Advice to decision maker on coal mining project

Proposed action: Cobbora Coal Project (EPBC 2011/6158) – New Development

Requesting agency	Department of Sustainability, Environment, Water, Population and Communities
Date of request	8 April 2013
Date request accepted	8 April 2013
Advice stage	Environment Impact Assessment (Supplementary)
Summary of request from the regulator	<p>The Department of Sustainability, Environment, Water, Population and Communities (the Department) is currently assessing the proposed project in accordance with the provisions of the <i>Environment Protection and Biodiversity Conservation Act 1999</i> (EPBC Act).</p> <p>The Department notifies the Independent Expert Scientific Committee on Coal Seam Gas and Large Coal Mining Development (the Committee) of an opportunity to comment on the Environmental Assessment and Preferred Project Report. Specifically, the Department seeks the advice of the Committee on whether:</p> <ol style="list-style-type: none"> 1. Does the Committee consider that the proponent has provided sufficient information on the water resources and its management to assess likely significant impacts from its proposed action? – If the informa

Figure 2.5 Conceptual hydrogeological cross-section B - B'

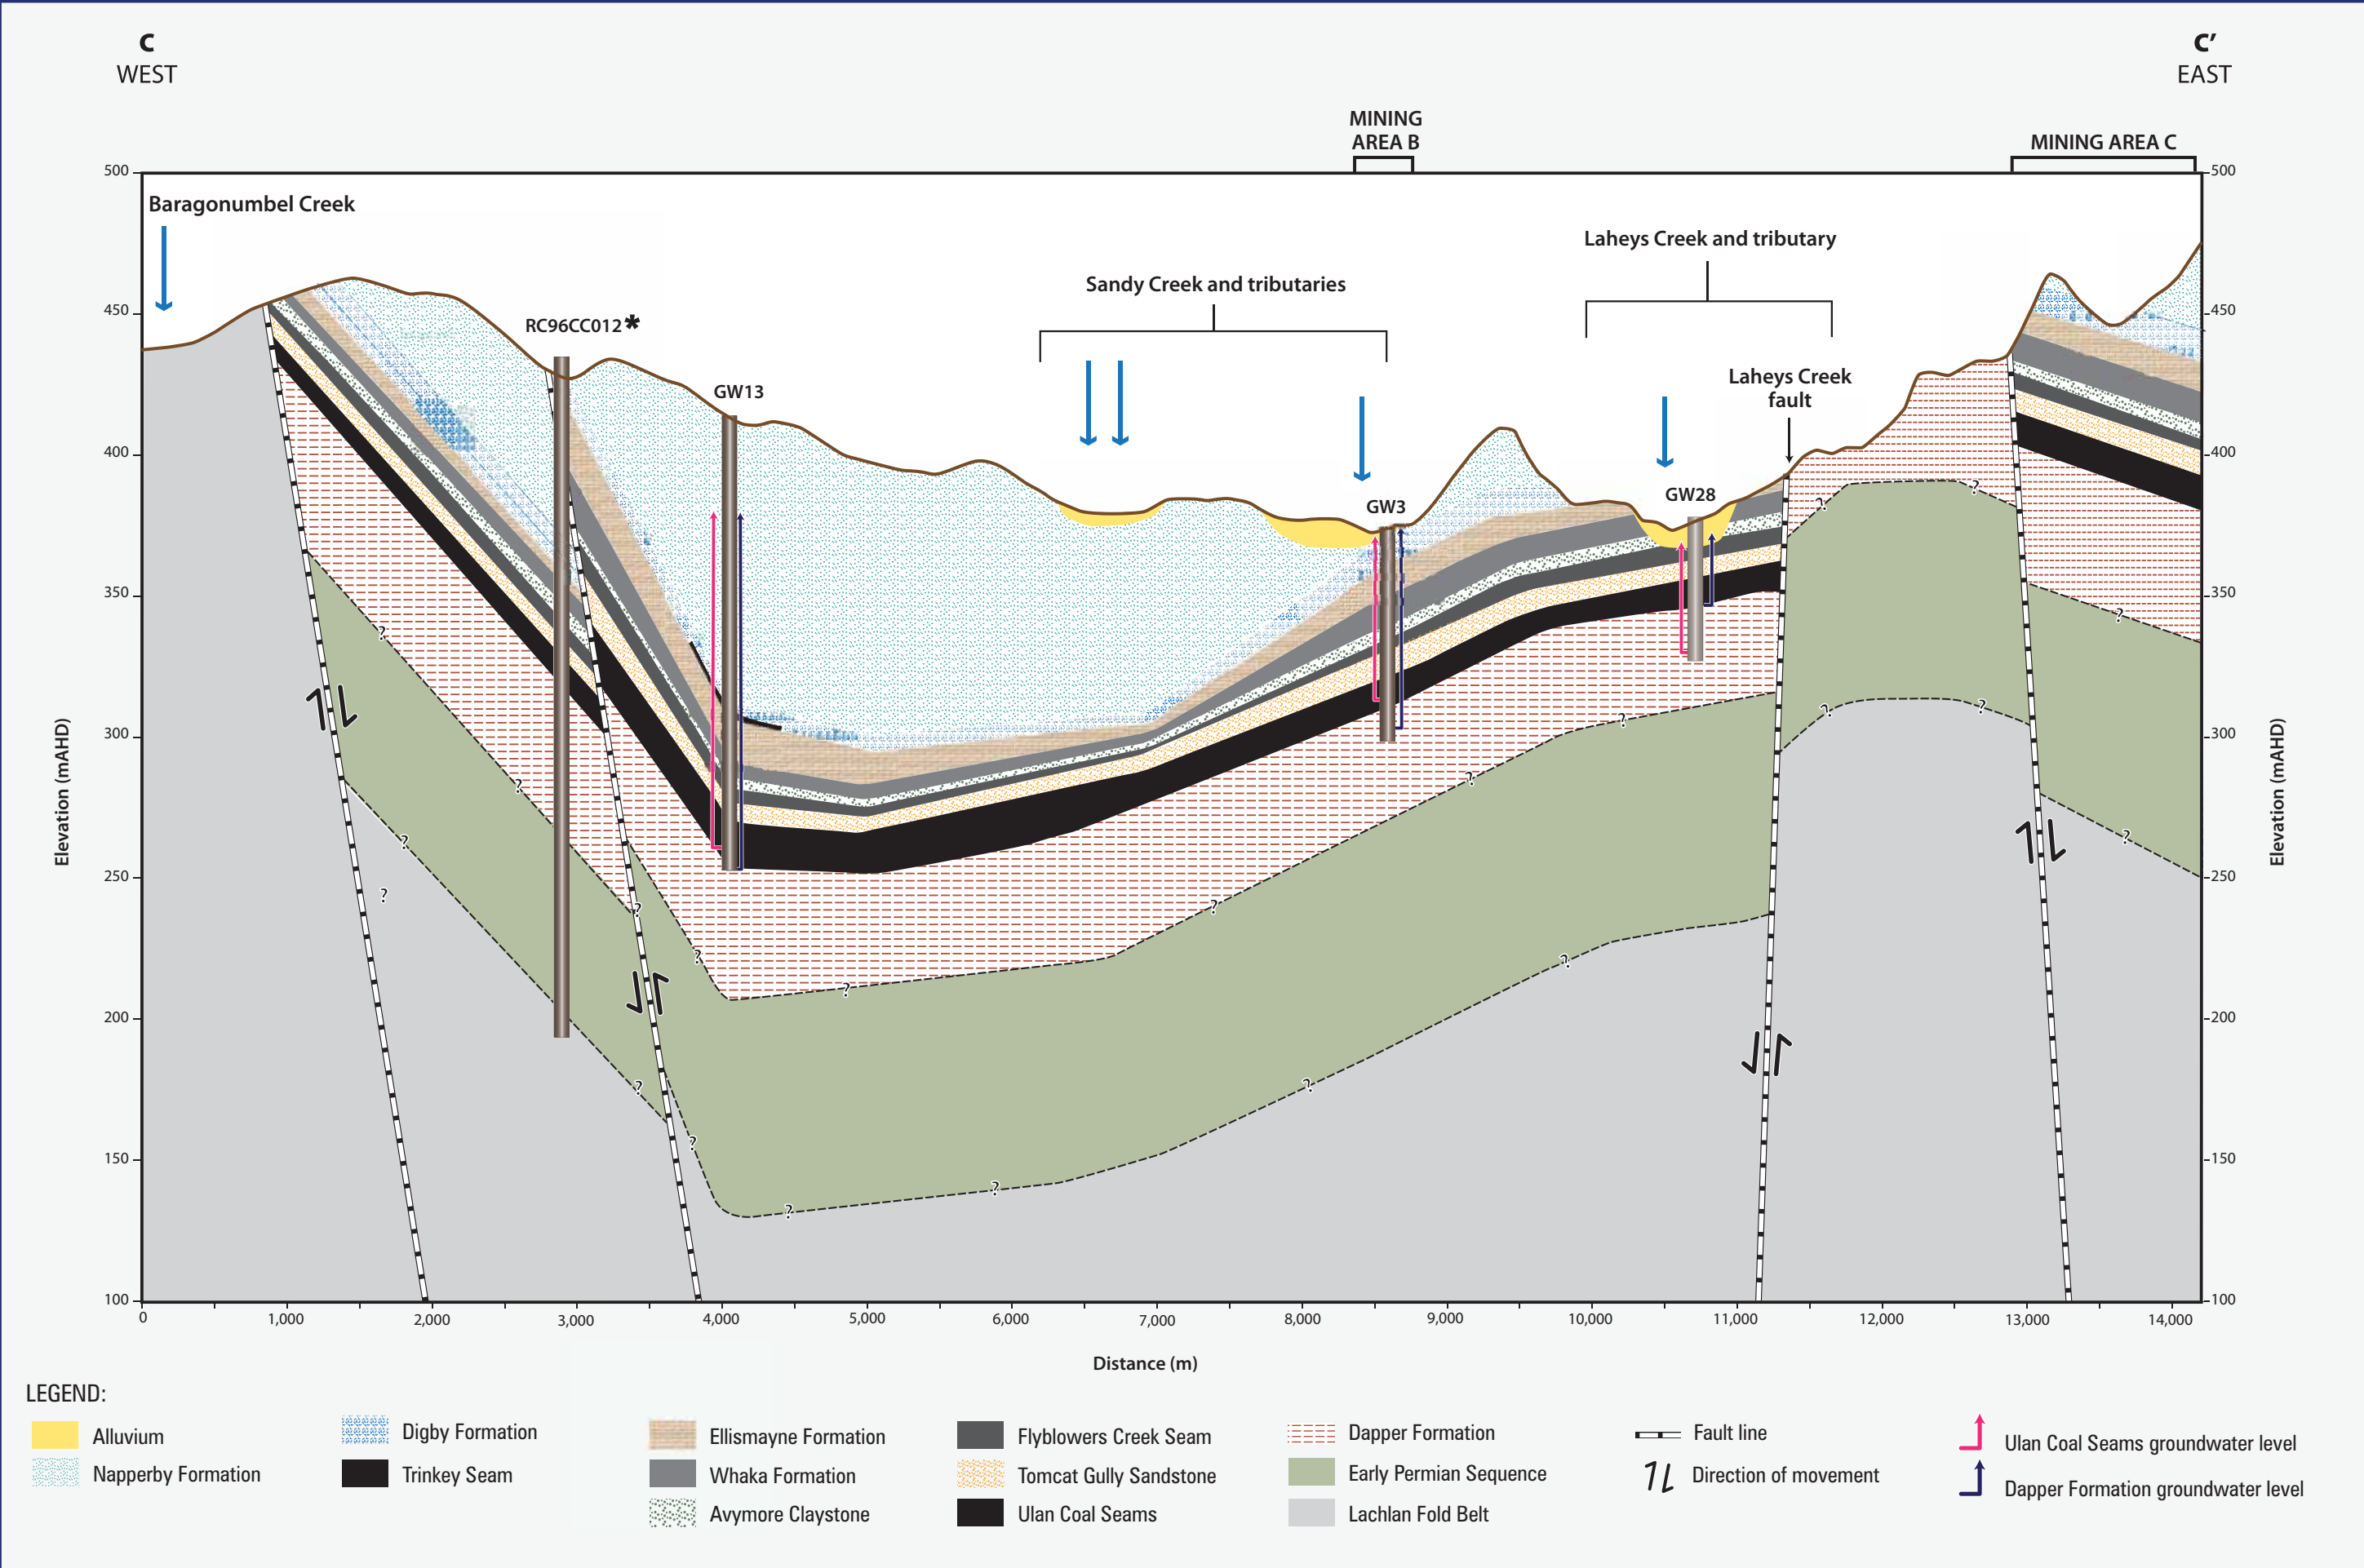
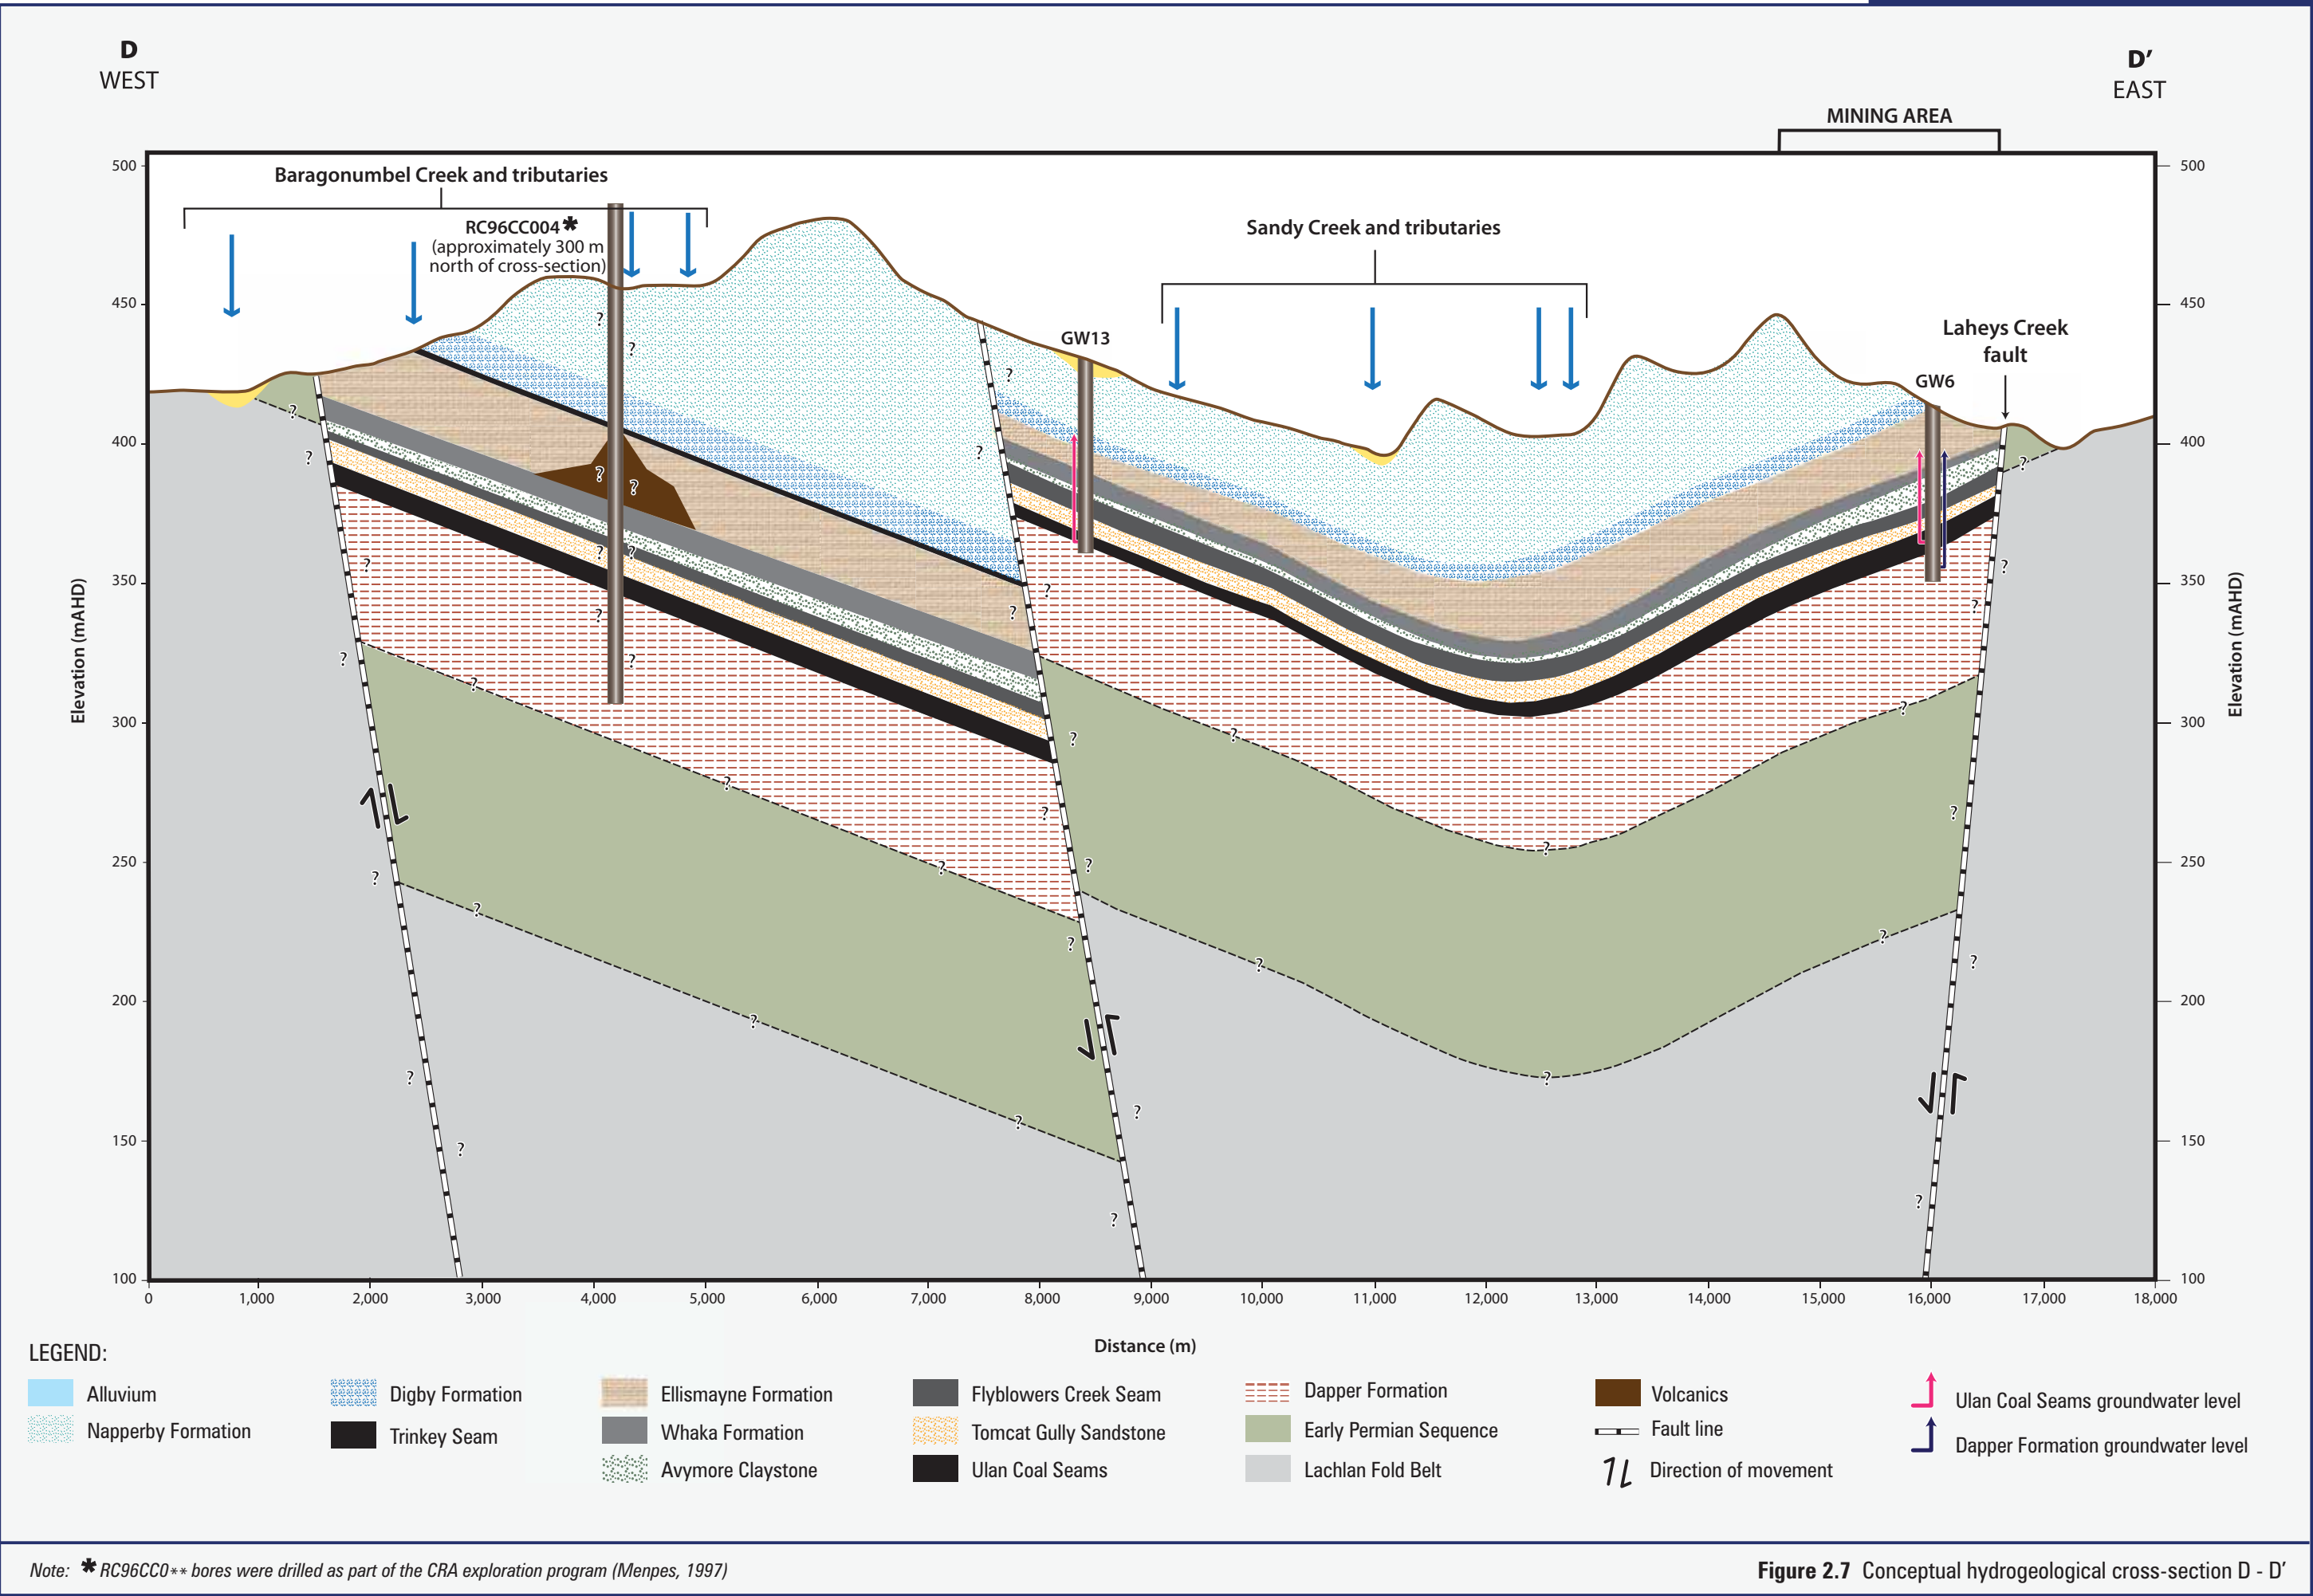
- b. The Jurassic Purlawaugh Beds are a major source of salt in the Sandy Creek sub-catchment and the Talbragar River catchment. The Jurassic Purlawaugh Beds and the Pilliga Sandstone, should be included in the geological conceptual model and then translated into the numerical groundwater model; and

- Geological conceptualisation model, including faulting and the Jurassic formations to reduce the uncertainty in regards to regional salinity impacts;
